WEST SUSSEX COUNTY COUNCIL CONSULTATION

TO:	Arun District Council FAO: Hannah Kersley
FROM:	WSCC – Highways Authority
DATE:	30 October 2024
LOCATION:	Winslade Court 10 Cavendish Road Bognor Regis PO21 2JW
SUBJECT:	BR/180/24/PL Change of use from 8 bedroom House in Multiple Occupation (HMO) to 11 bedroom HMO. This application is in CIL zone 4 and is CIL liable.
DATE OF SITE VISIT:	n/a
RECOMMENDATION:	No Objection

Drawing Title
Proposed Site Plan and
Bike Store

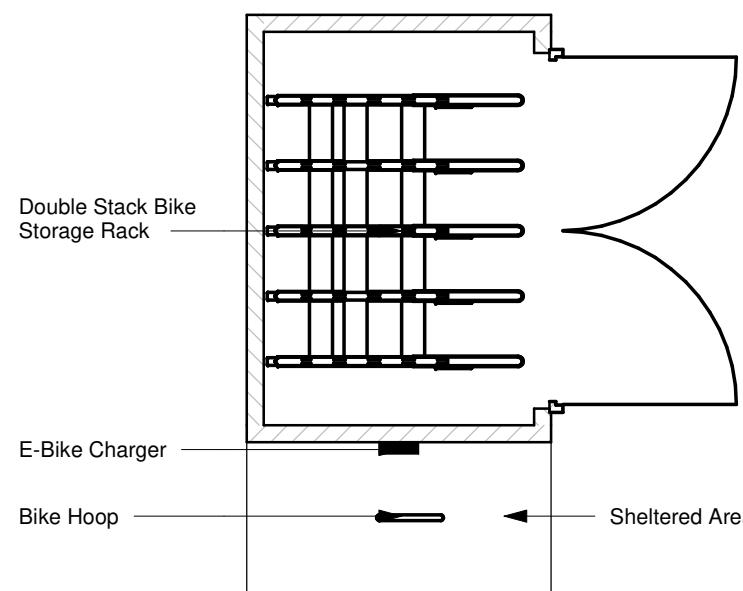
A safe and secure bicycle parking provision is provided to the rear of the garden conveniently accessible through a side entrance.
